## Health Precinct Stage 1

### DESIGN EXCELLENCE REVIEW PANEL

Update to Support State Significant Development Application

July 2017

UOS HEALTH PRECINCT – STAGE 1 PEDESTRIAN CIRCULATION - LEVEL 0

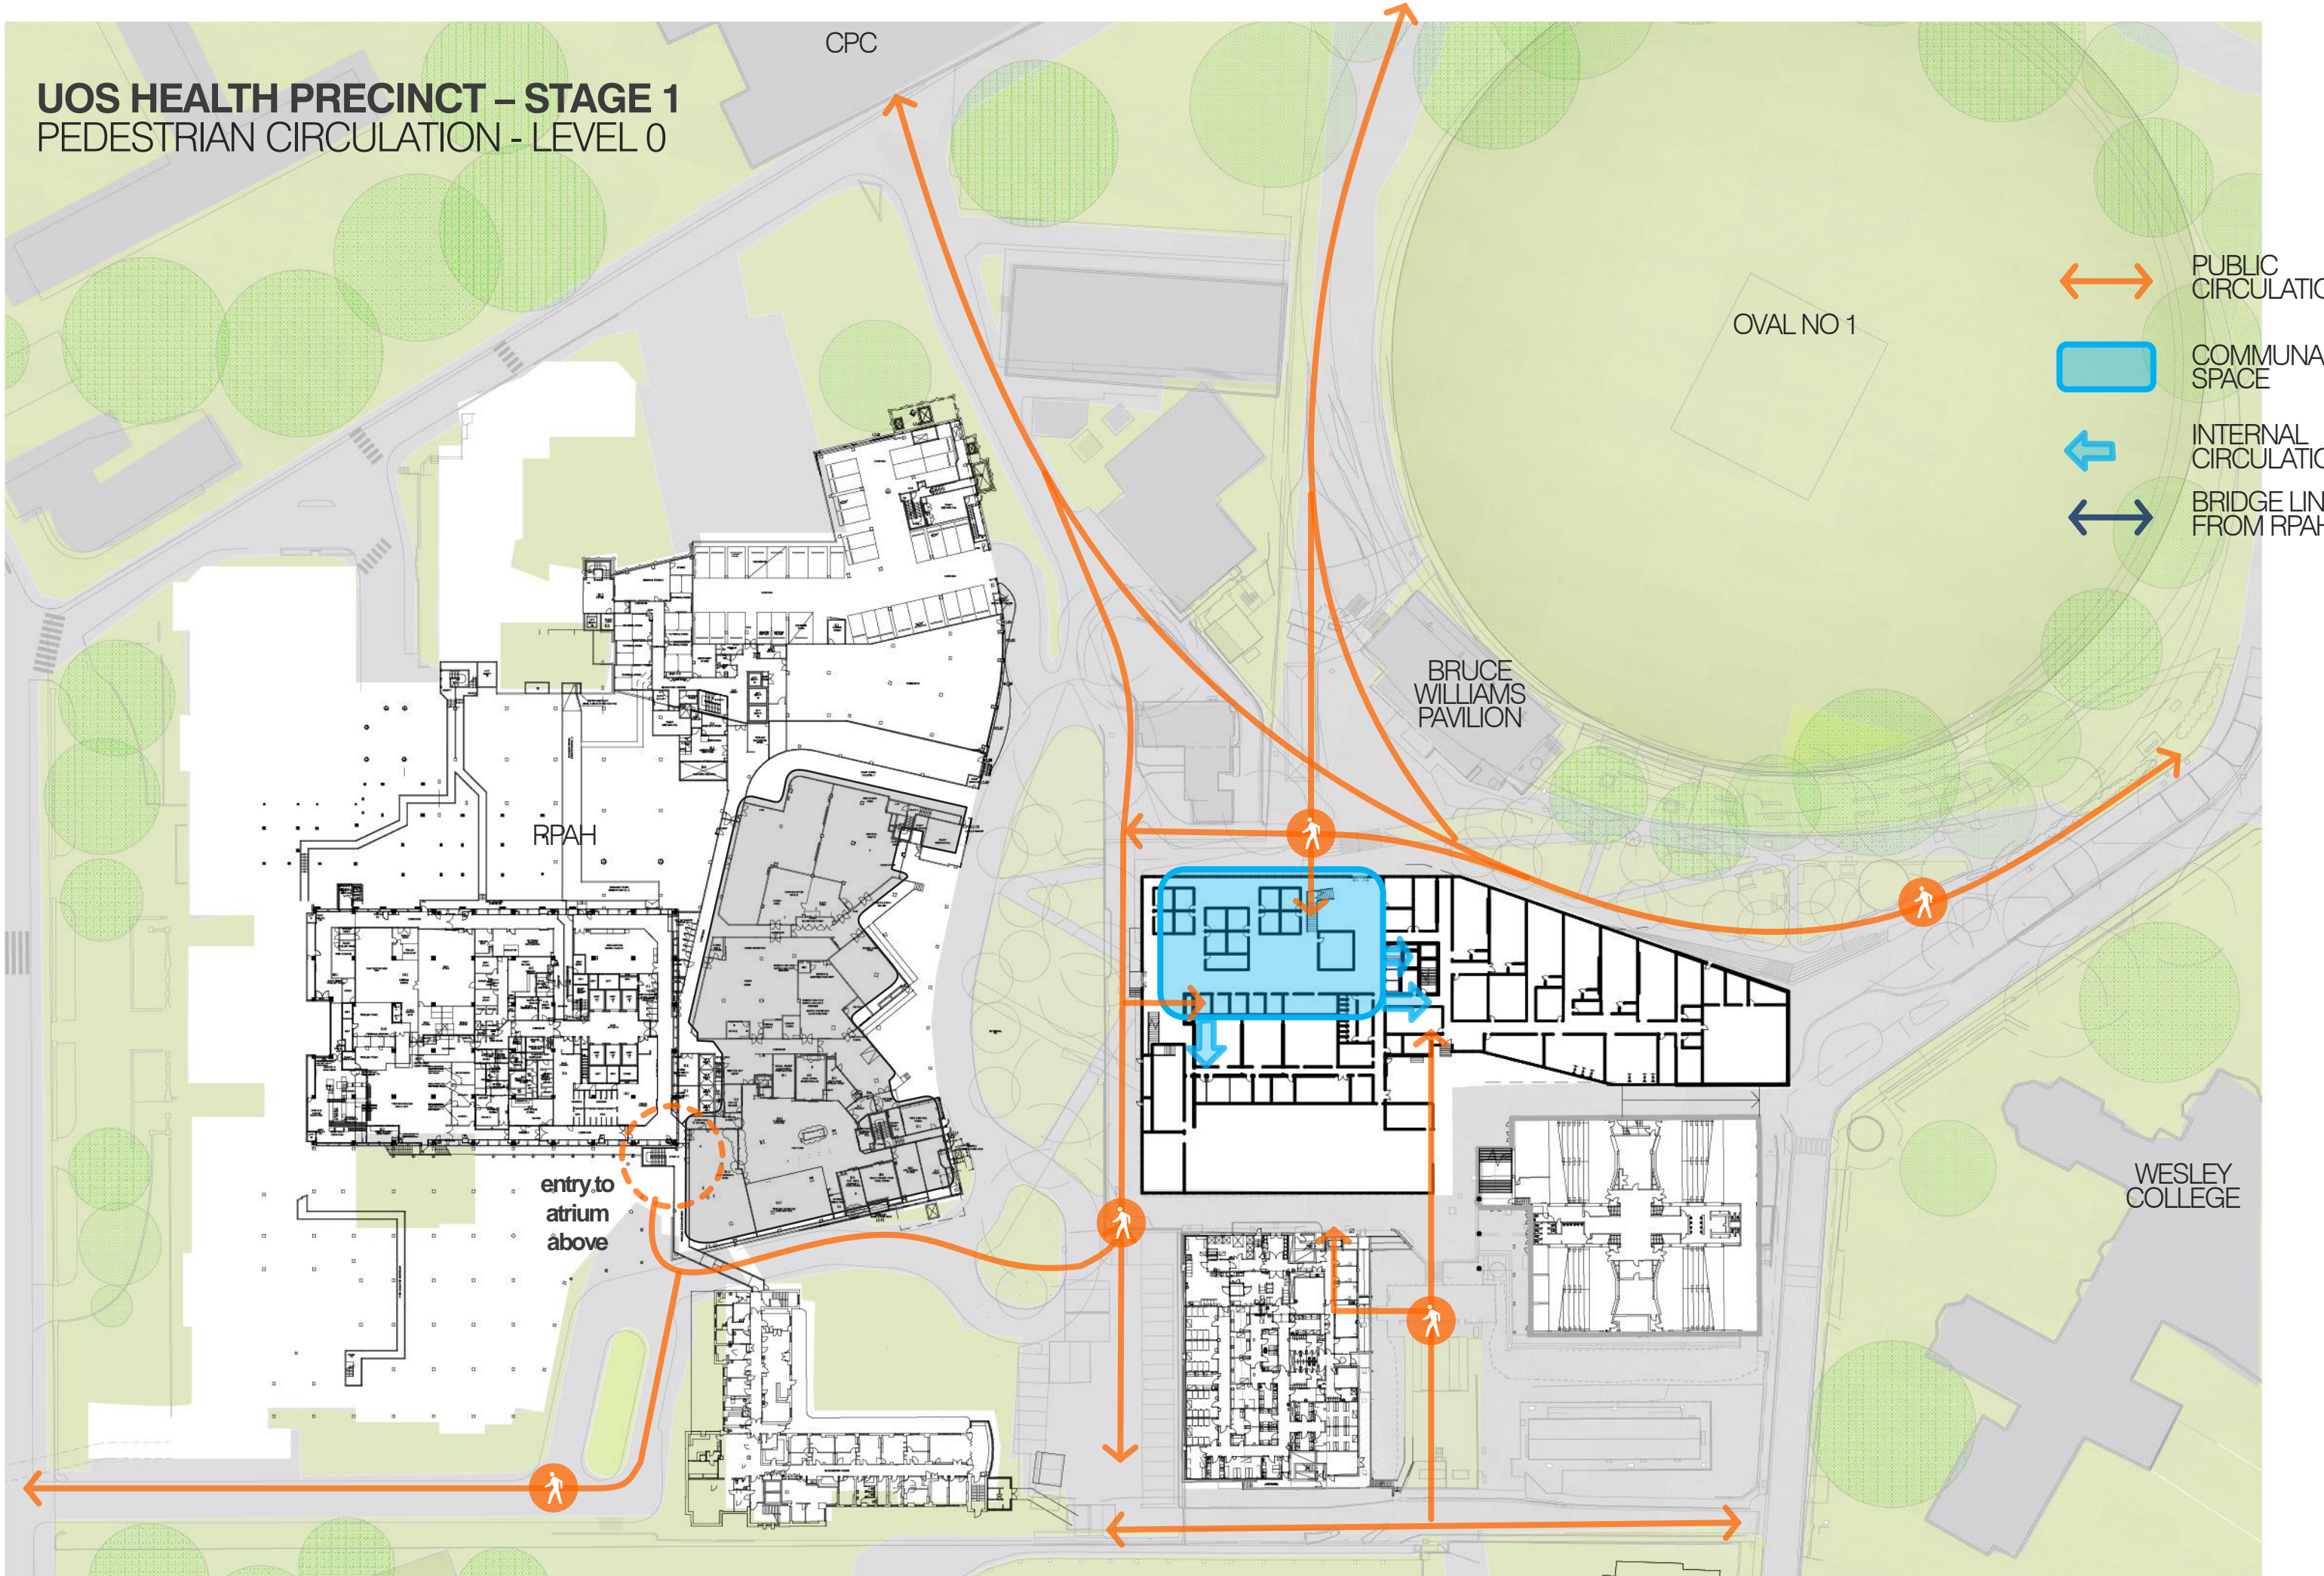
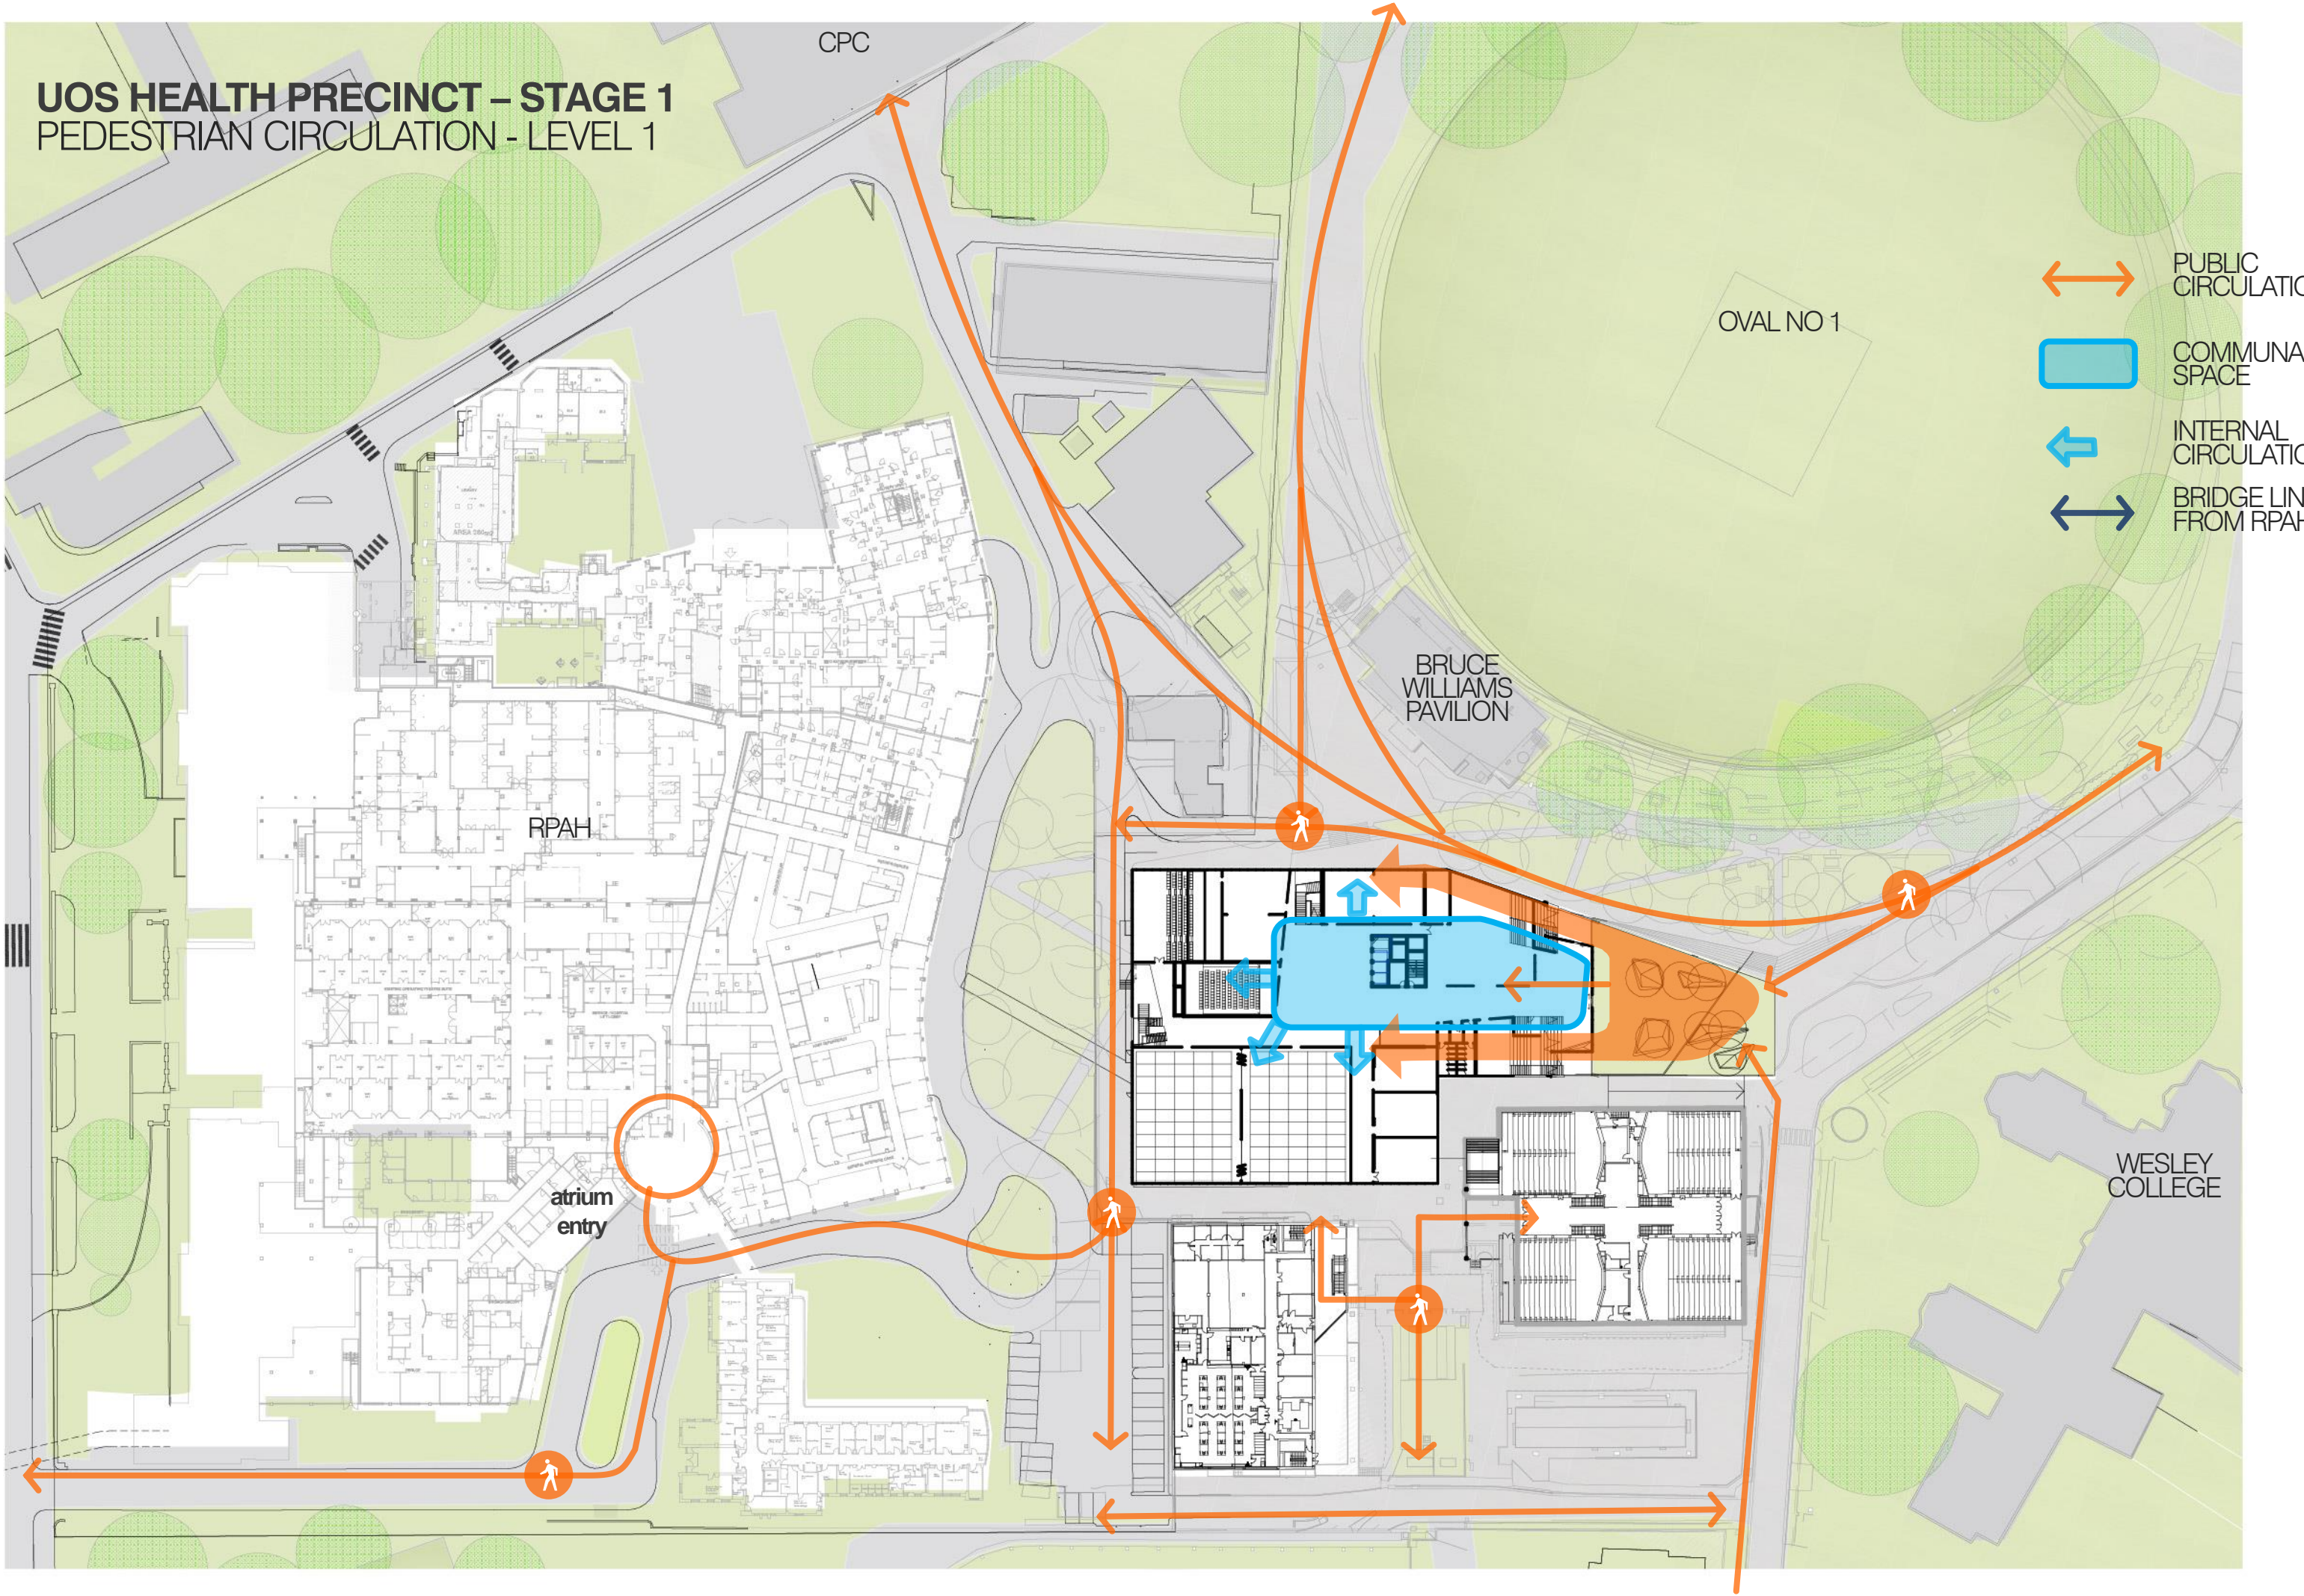
Ref	DCJ design excellence issue	Design refinement
1	Pedestrian flow studies would be useful to measure pedestrian use in peak periods to test for congestion	Flows were analysed and design modified to increase circulation corridors and stair widths
2	<p>Landscape solution should be reviewed in relation to the following:</p> <ul style="list-style-type: none"> <li>• consider a reductive approach to some of the elements eg water features</li> <li>• Review disposition of building elements below the main entry to enable soil depths that facilitate tree planting. Consider retention or relocation of the existing fig tree</li> <li>• Reconsider overland flow strategy and drainage edges</li> </ul>	<p>Landscape scheme has been significantly refined:</p> <ul style="list-style-type: none"> <li>• Water feature has been simplified with areas of water flow replaced with misters</li> <li>• Opportunities for deep soil planting and large trees at the entry have been significantly increased. Arborist advice in relation to the fig has confirmed that general condition including tree roots does not warrant retention.</li> <li>• Overland flow has been satisfactorily addressed with a clear strategy of capture, storage and release that utilises underground zones created by the demolition of the Blackburn building with inlets and outlets integrated with landscape areas.</li> </ul>
